SCOPING OPINION:

Proposed A1 Birtley to Coal House Improvement Scheme

Case Reference: TR010031

December 2017

**OUTLINE GENERAL ARRANGEMENT TIED ARCH
FOOTBRIDGE OPTION**

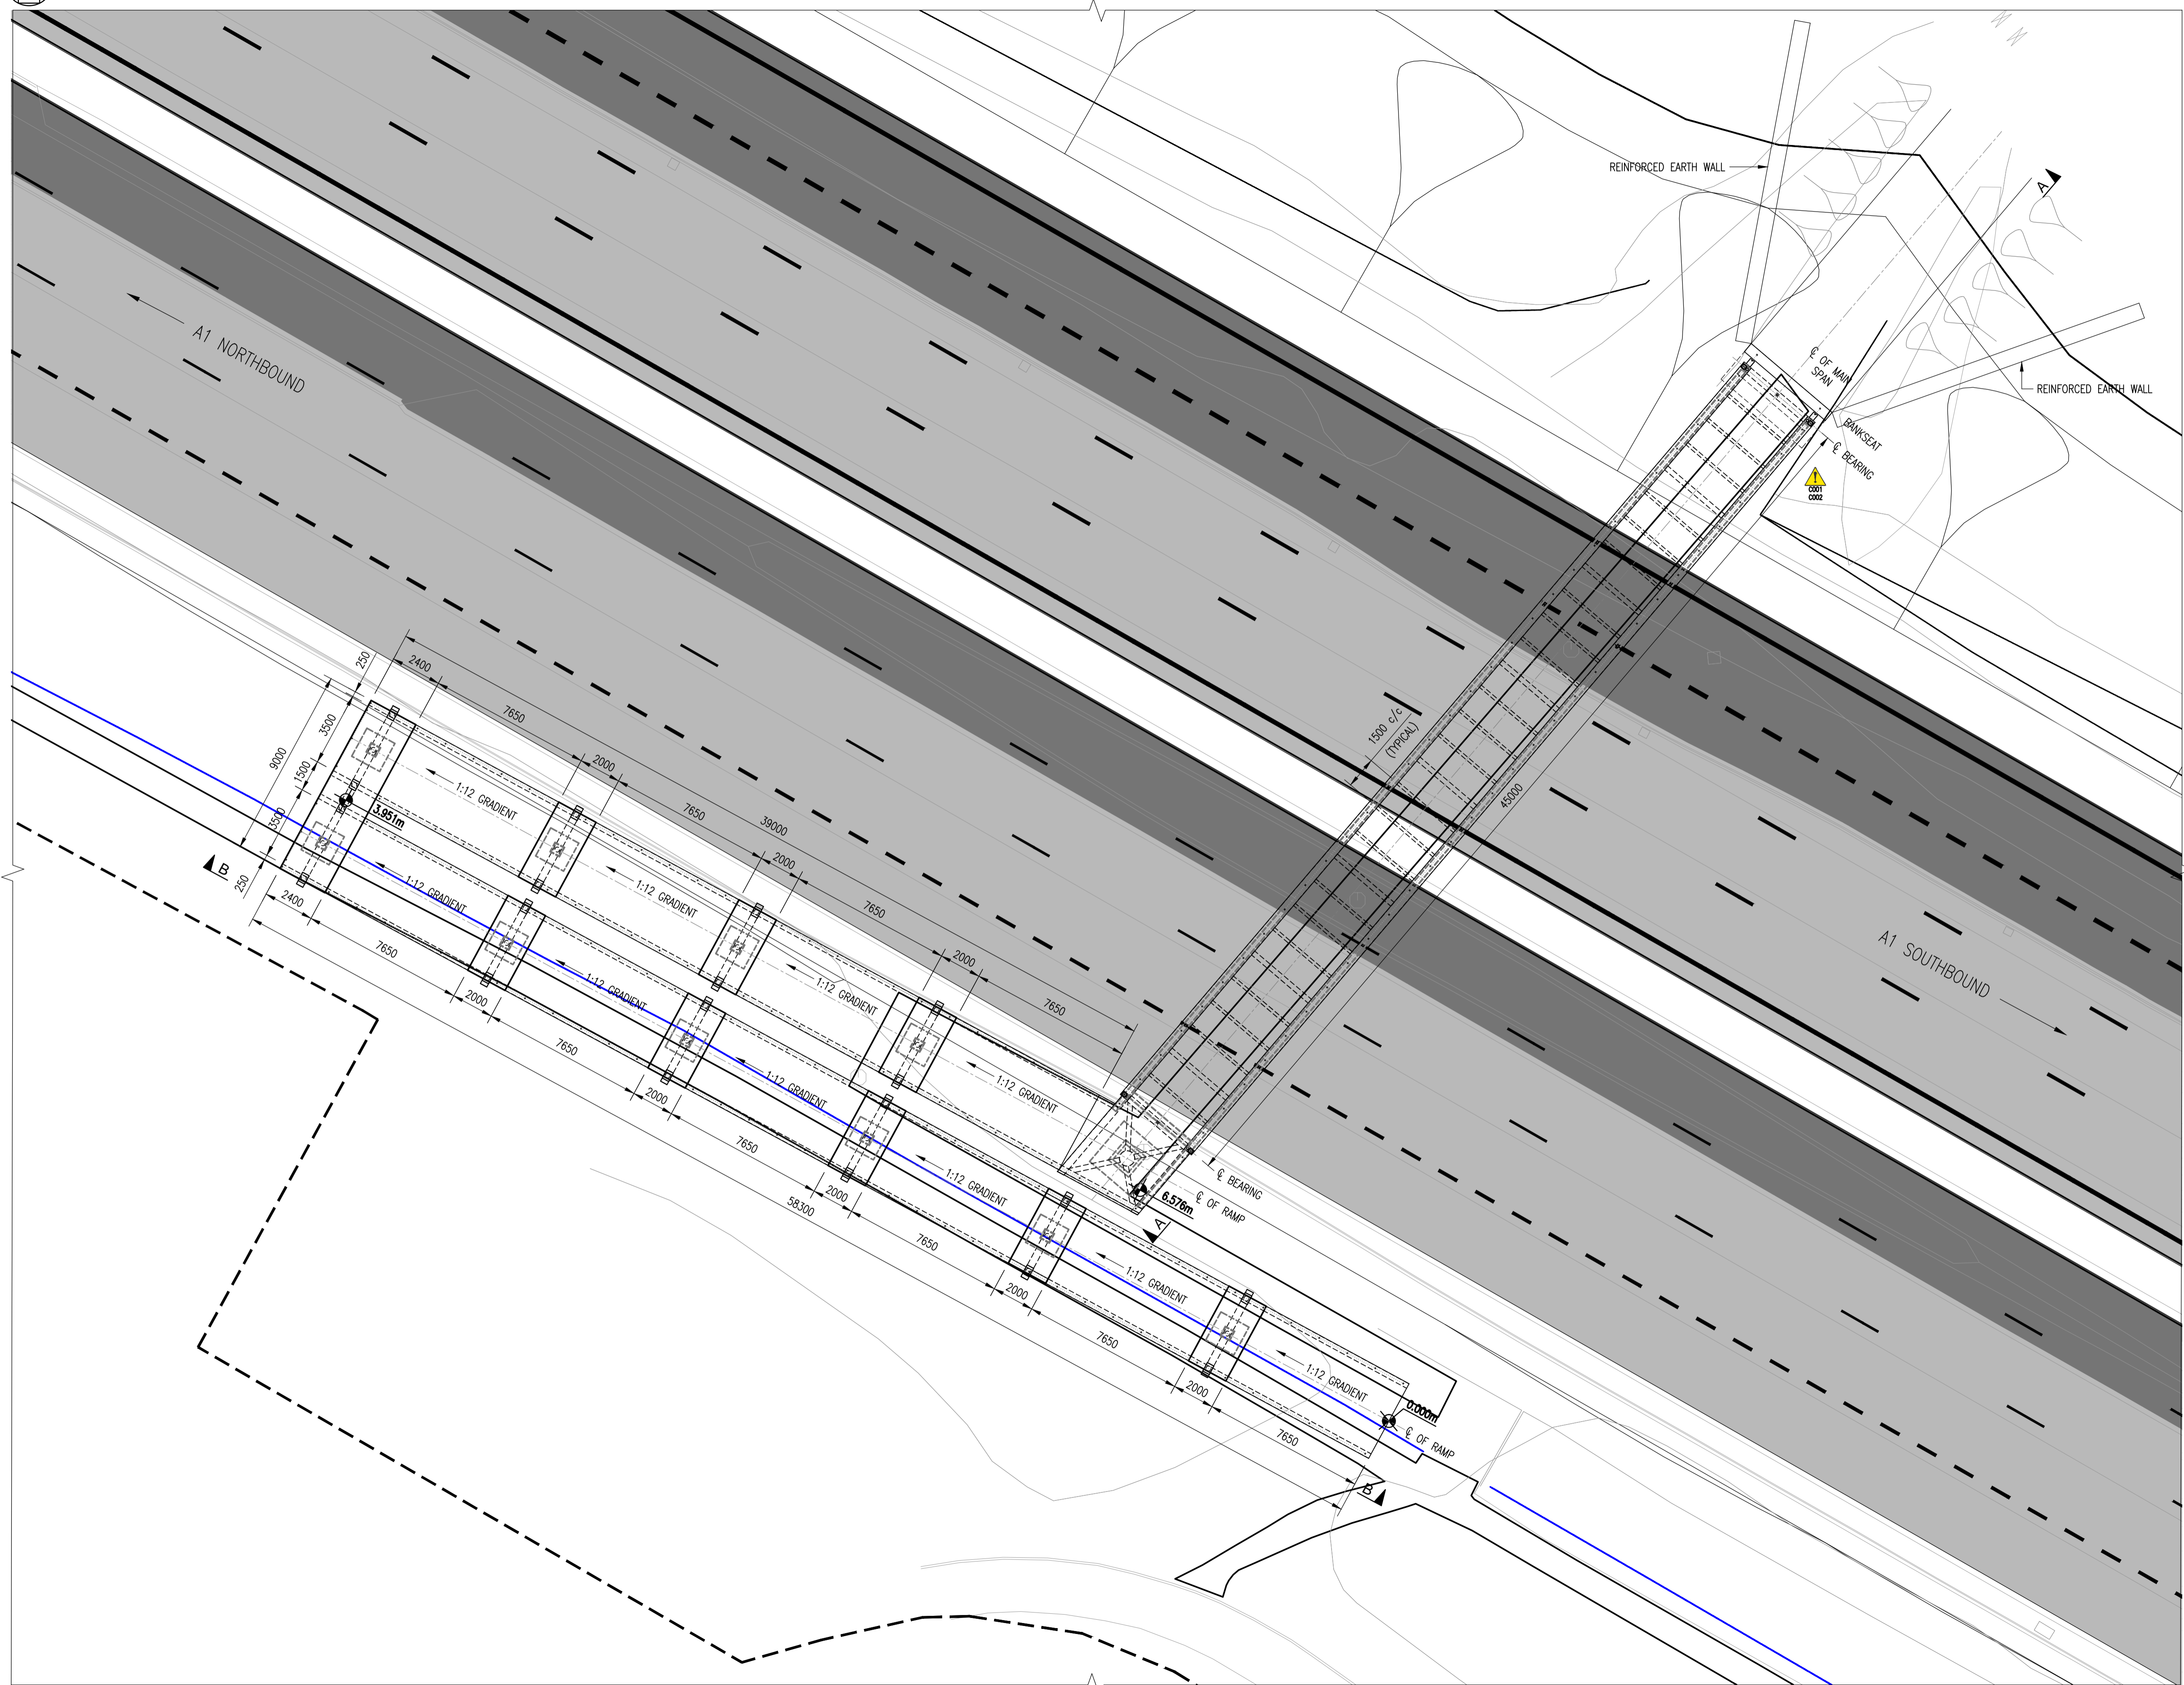
- 2.3.7 Paragraph 12.5.1 of the Scoping Report explains the intention to deconstruct the North Dene footbridge and re-use this elsewhere on the highway network. The feasibility of doing this will be confirmed as the design phase progresses. The ES should describe the works necessary to inform the assessment of the likely impacts associated with this.
